Our Ref: BN/120/19/HH
Your Ref:

Town & Country Planning Act 1990 (as amended)
Town & Country Planning (Development Management Procedure) (England) Order 2015
Application for Planning Permission for Works or Extension to a Dwelling

Development Proposed single storey rear extension
Location Swallowfield Eastergate Lane Eastergate

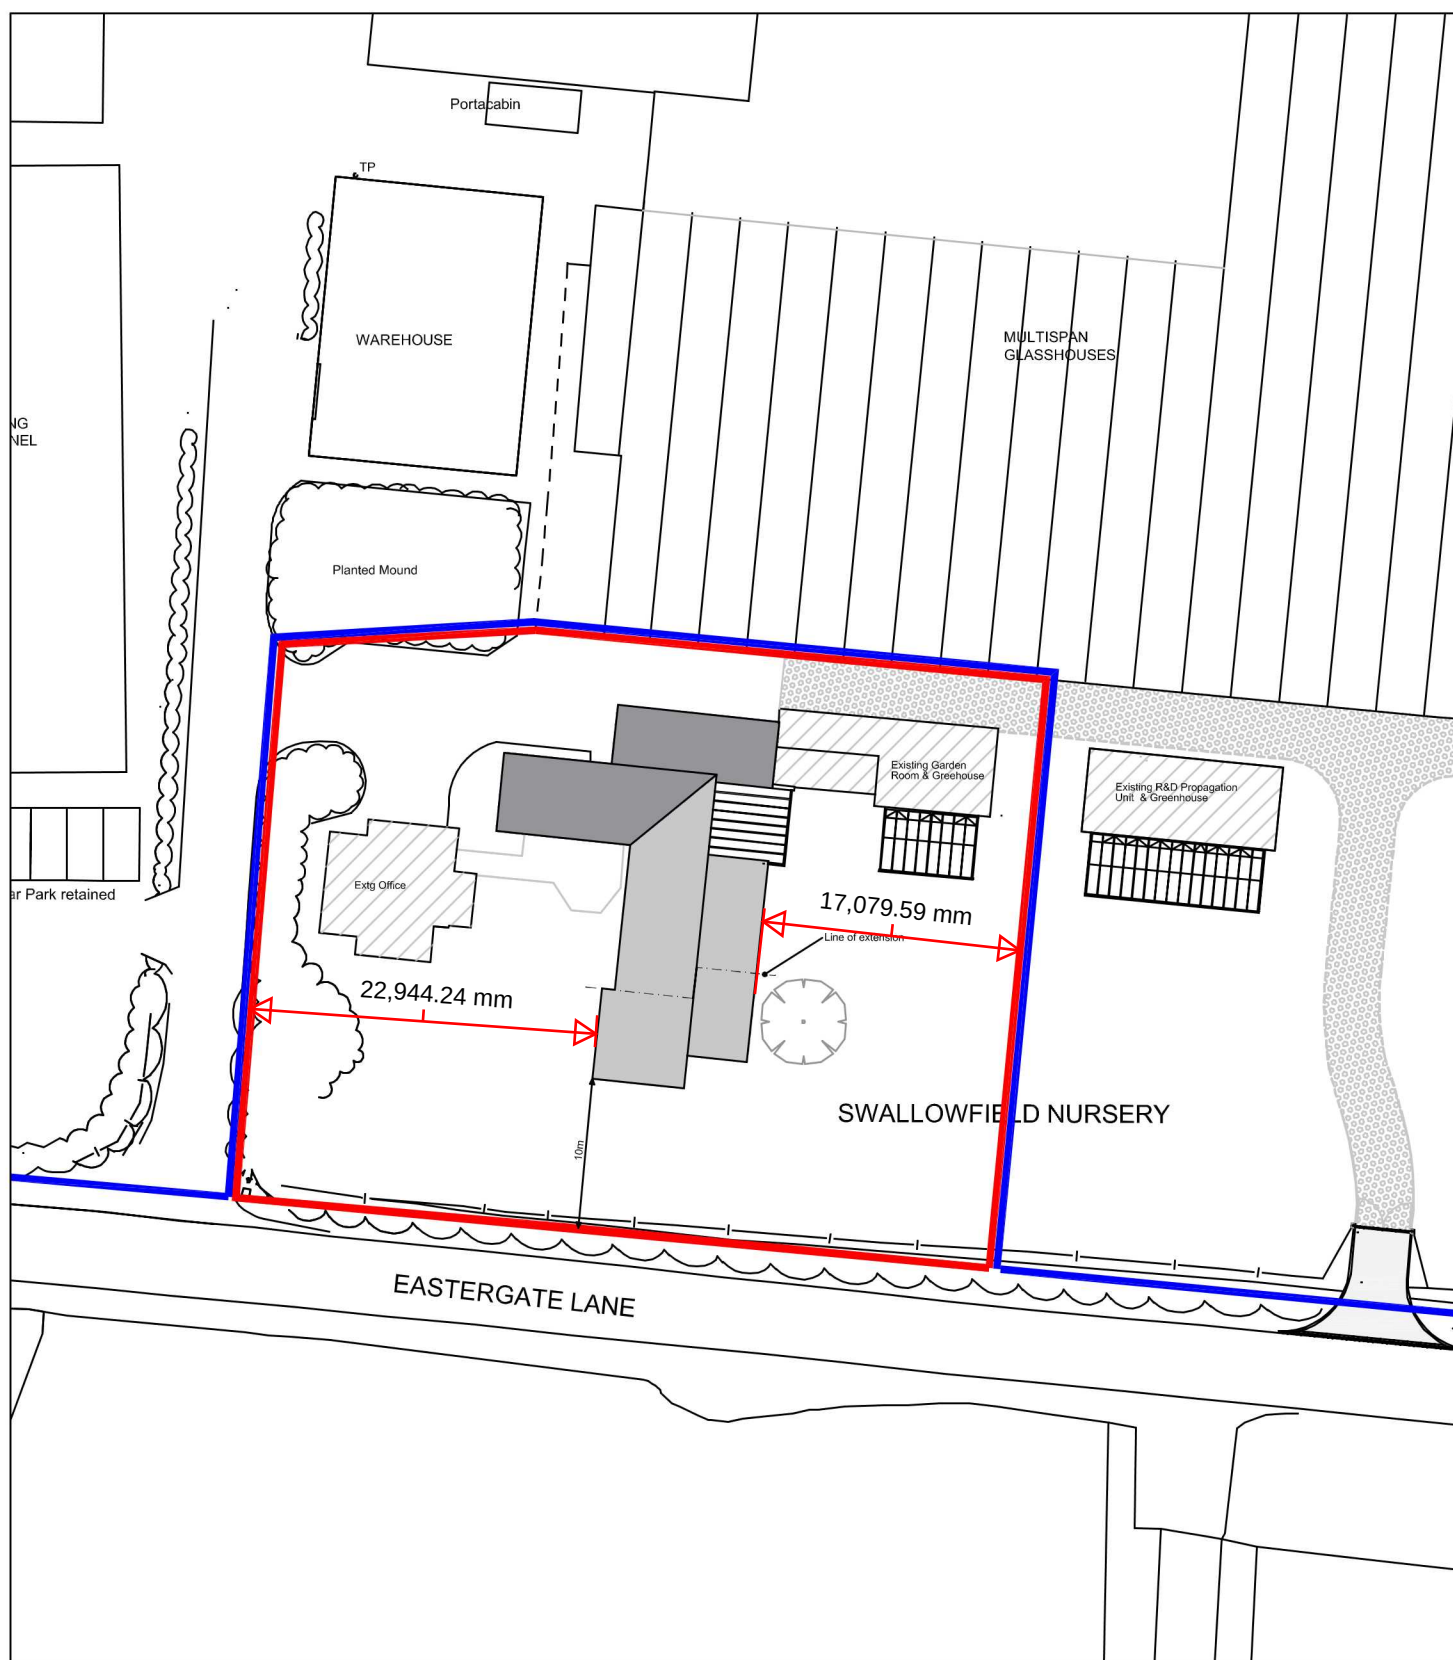
Block Plan: It is a local requirement that dimensions are included on all block plans from the proposed extension to all site boundaries. Please amend.
